Recommendation Report for Planning Permission for Works or Extension to a Dwelling

REF NO: LU/90/21/HH

LOCATION: 2 Elspring Mead
Littlehampton
BN17 7JE

PROPOSAL: Installation of drop kerb and driveway

Block Plan Showing vehicular crossover
for 2 Elspring Mead

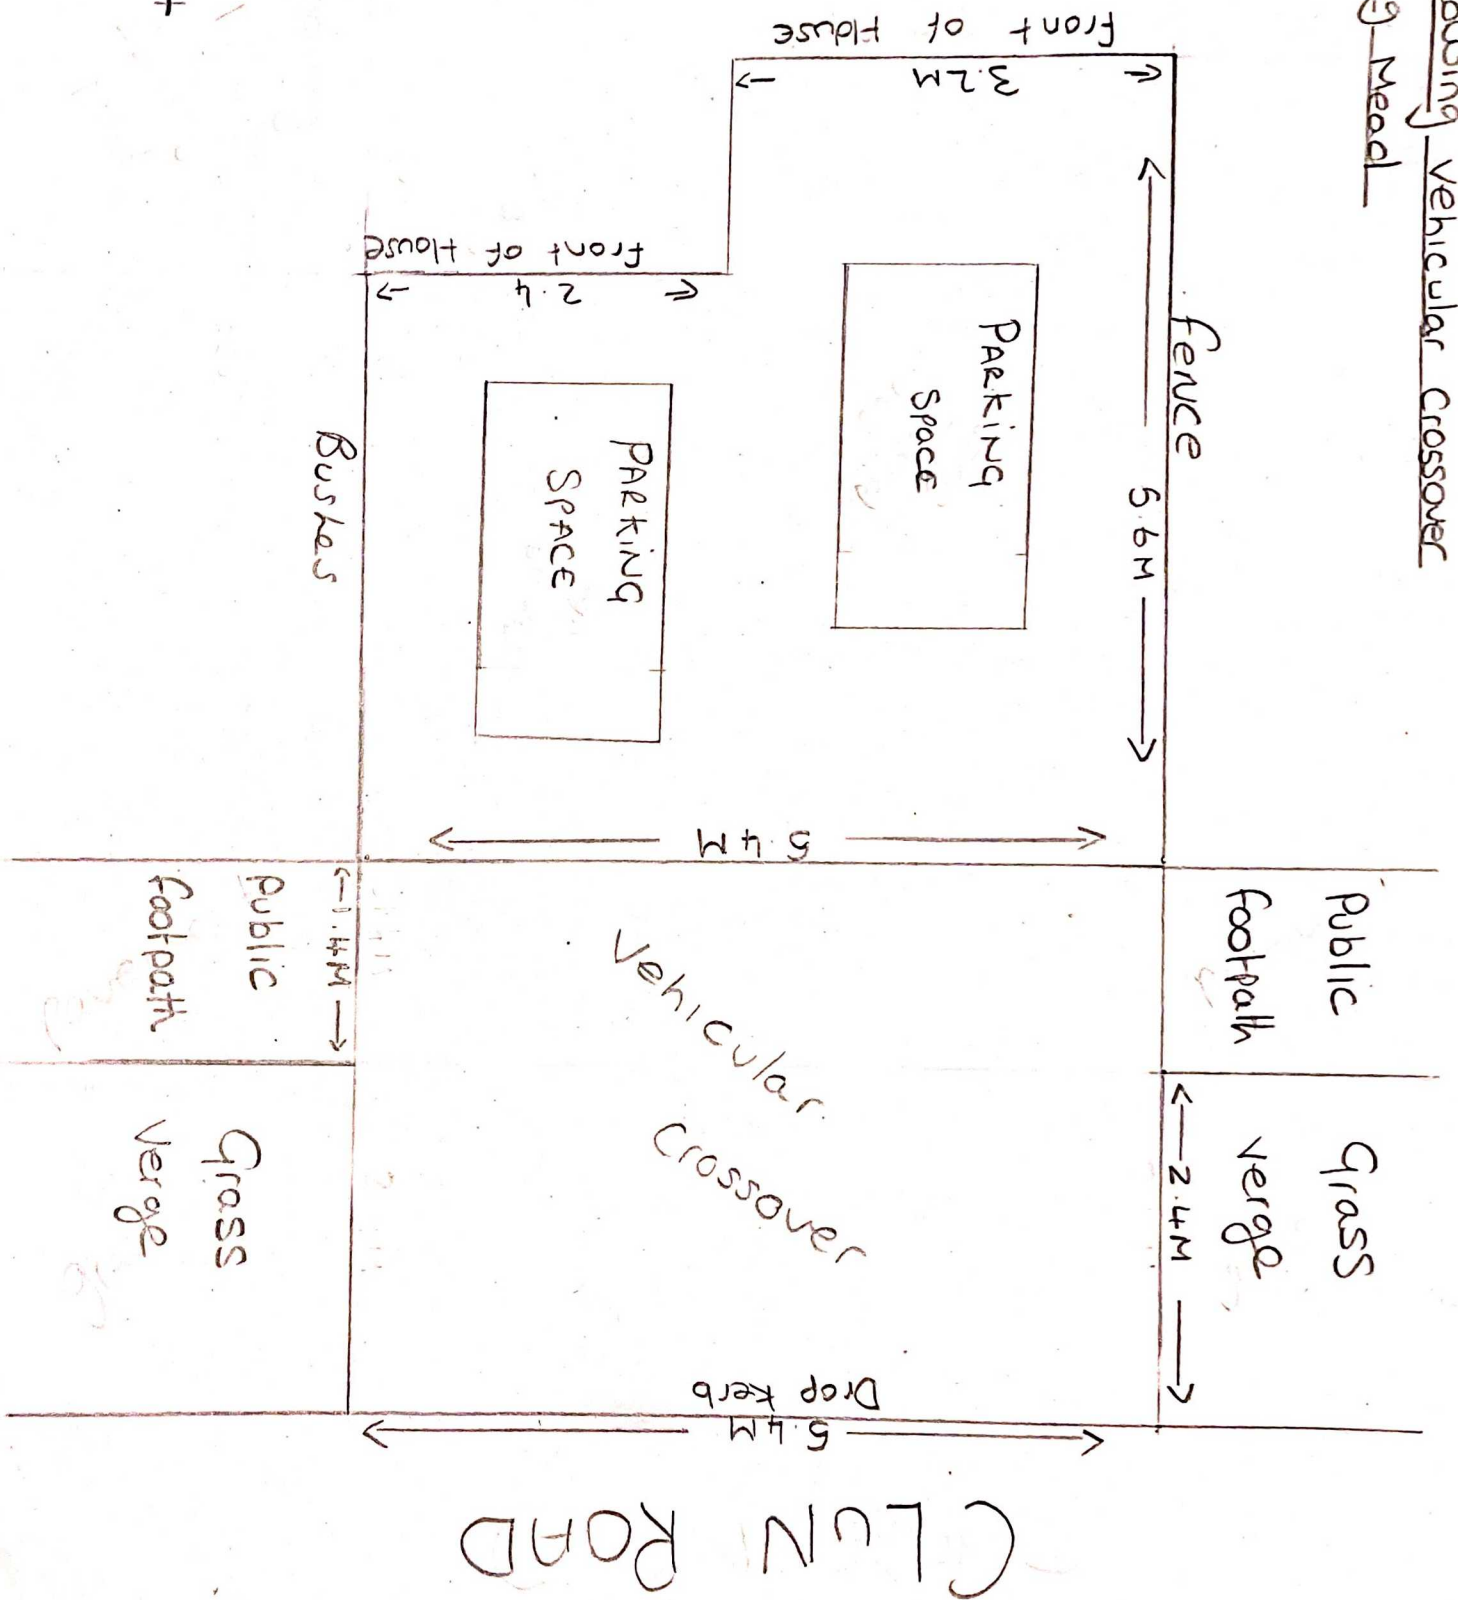
The vehicular crossover (VCO) will be 5.4m wide and must be constructed to a specification agreed with the WSCC Highways. Visibility at the access is sufficient for the anticipated road speeds in this location. The plans demonstrate two parking spaces on the driveway. The applicant will need to make an application to County highways for a crossover license in order to commence this aspect of the development when highway safety is a consideration and as such the proposal is in accordance with policy T SP1 of the Arun Local Plan.

Reason: For the avoidance of doubt and in the interests of amenity and the environment in accordance with policy DDM4 of the Arun Local Plan.
- 3 INFORMATIVE:- On the basis of the information available the Local Highway Authority is not satisfied that the proposed development can be undertaken in a satisfactory manner due to the depth of the parking space. You should view the comments from WSCC on our website.
